RE: Hoffmantown Office Building

H19 - D24

RE: HOFFMANTOWN OFFICES DRAINAGE PLAN

My comments regarding the referenced plan:

TITLE: HOFFMANTOWN OFFICES DRAINAGE-GRADING PLAN

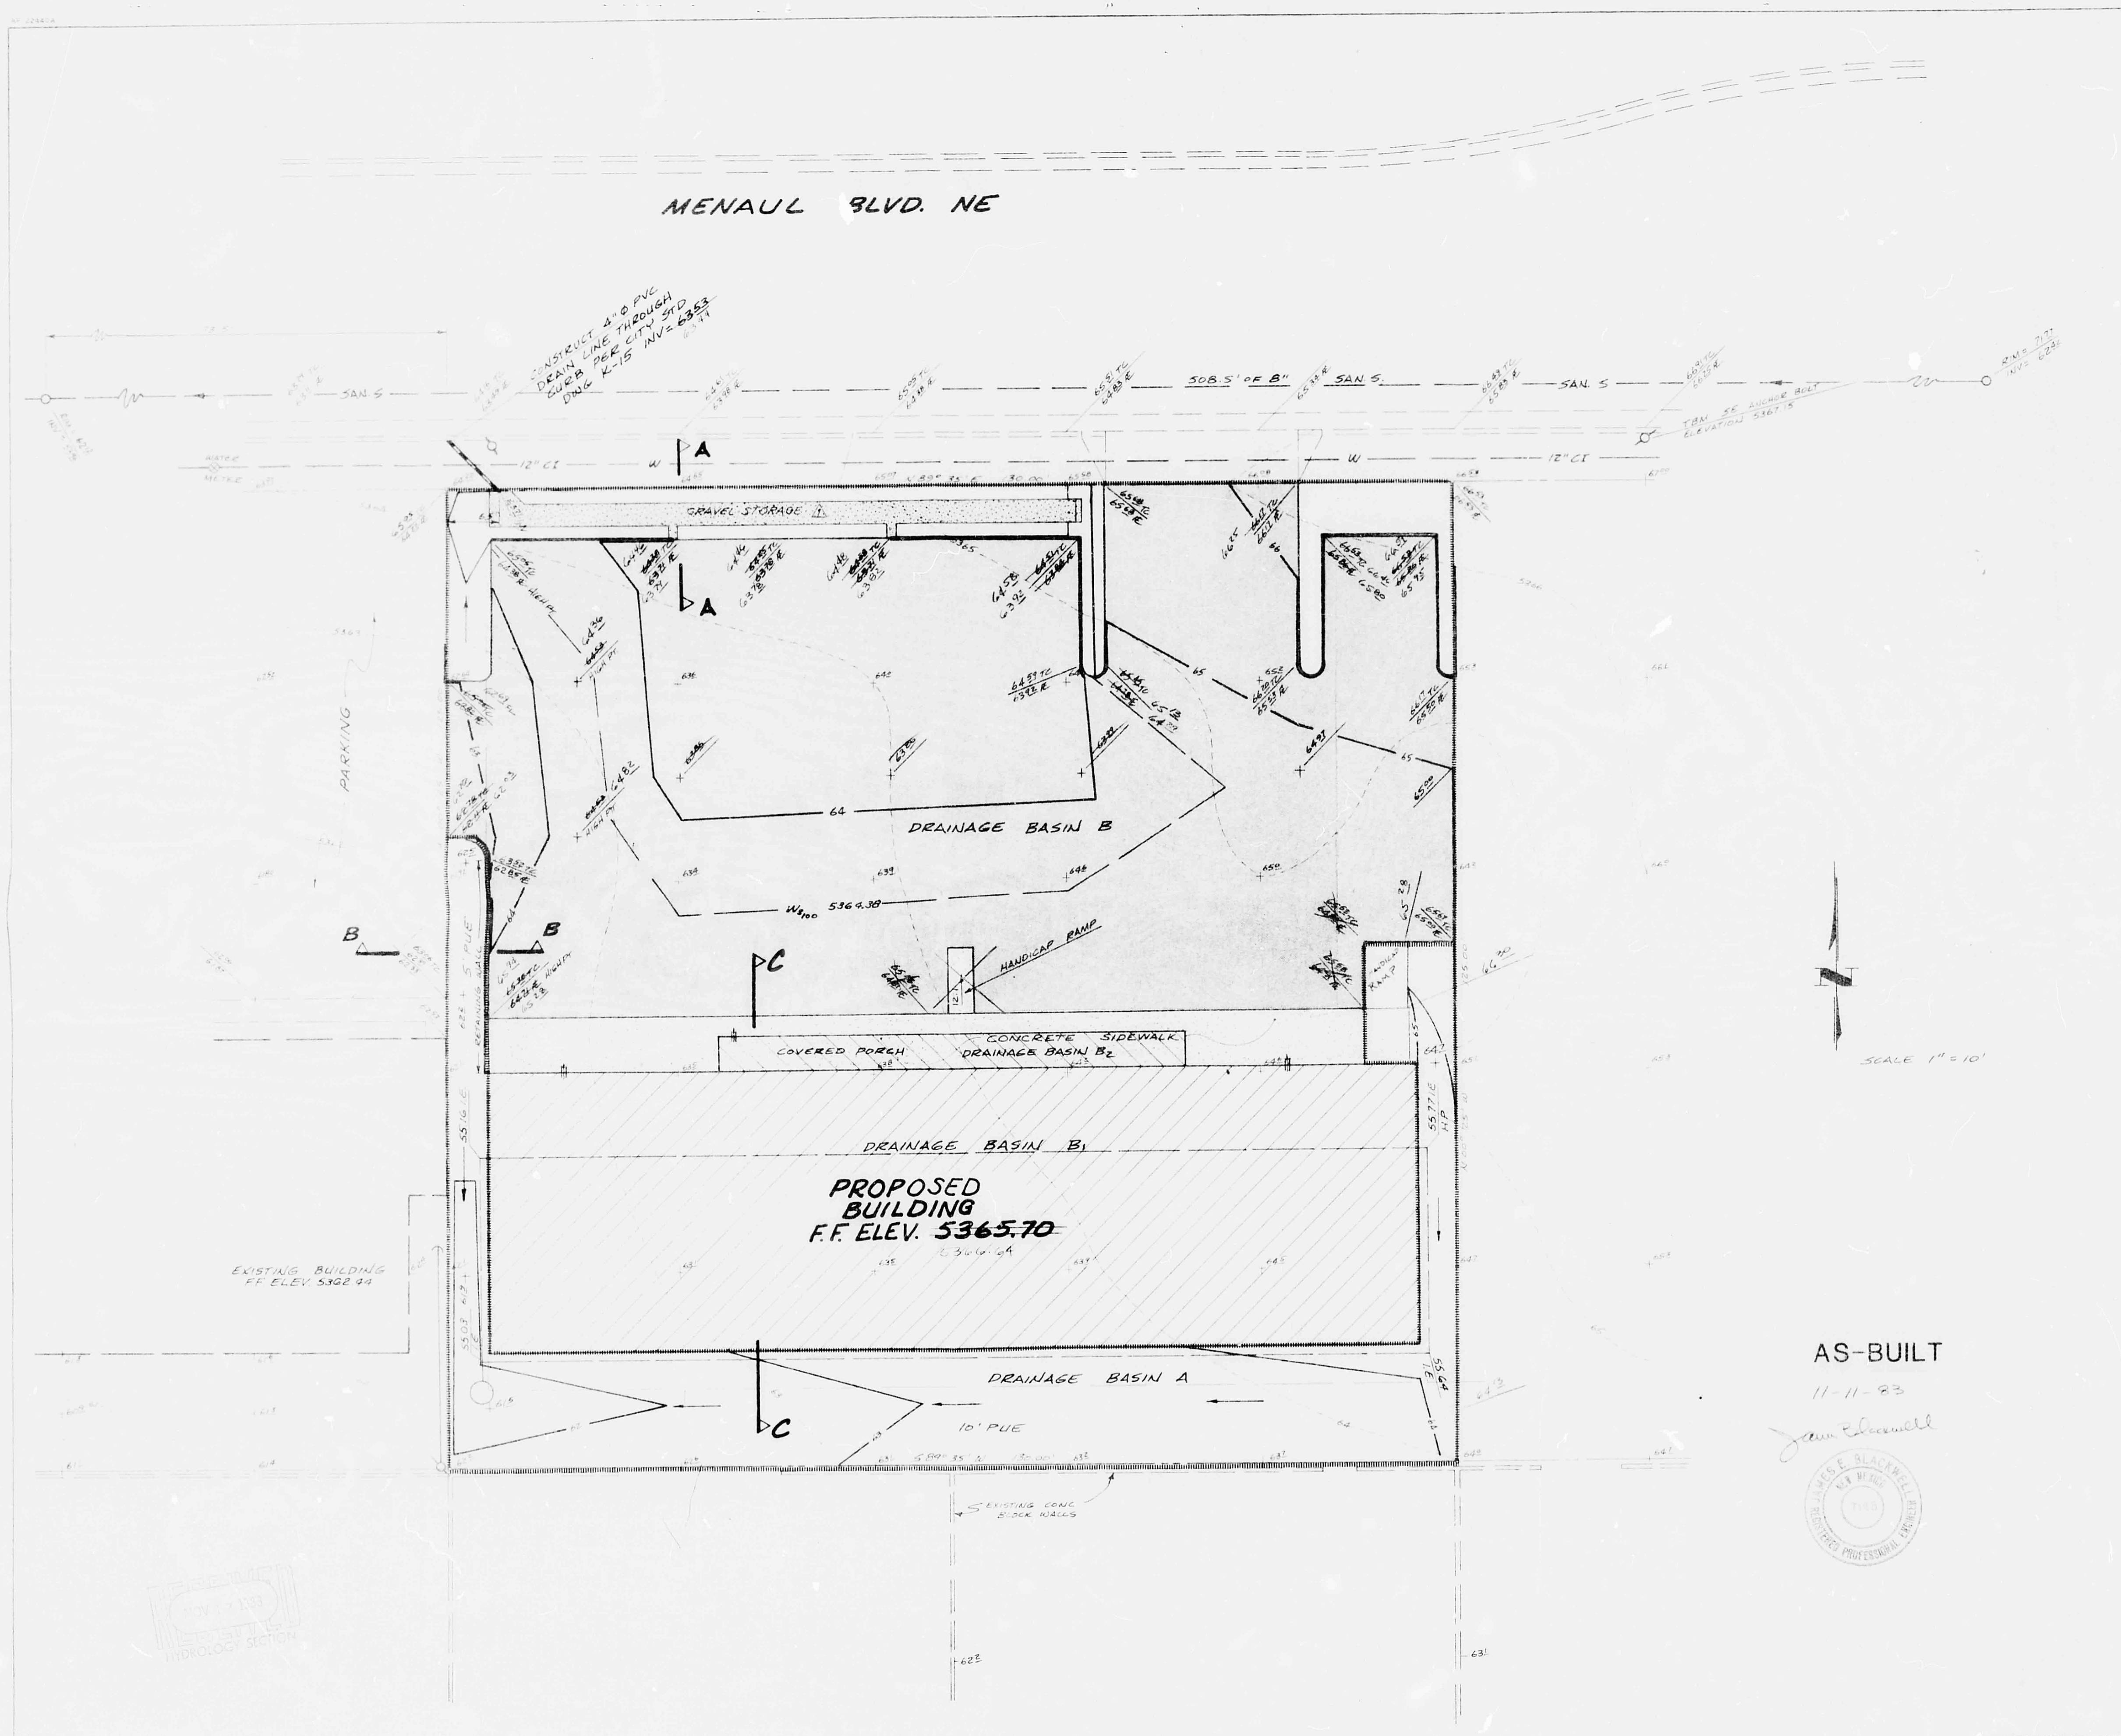
1. Why is runoff in the southwest corner to be ponded? At one time, I stated it was acceptable to tie the swale to the existing paved surfaced at the west boundary.
2. Does the Drainage Basin B boundary represent direction of roof drainage? If so, where will the canales be located?
3. I'm abit confused about the grade difference between the finished floor elevation and the adjacent west alley way. Will part of the foundation be exposed in this corner?
4. What is the finished floor elevation of the adjacent building?

Additional information has been added to the drawings in regard to your comments. Also, attached to the drawings is a copy of the Special Order 19, which is for your information.
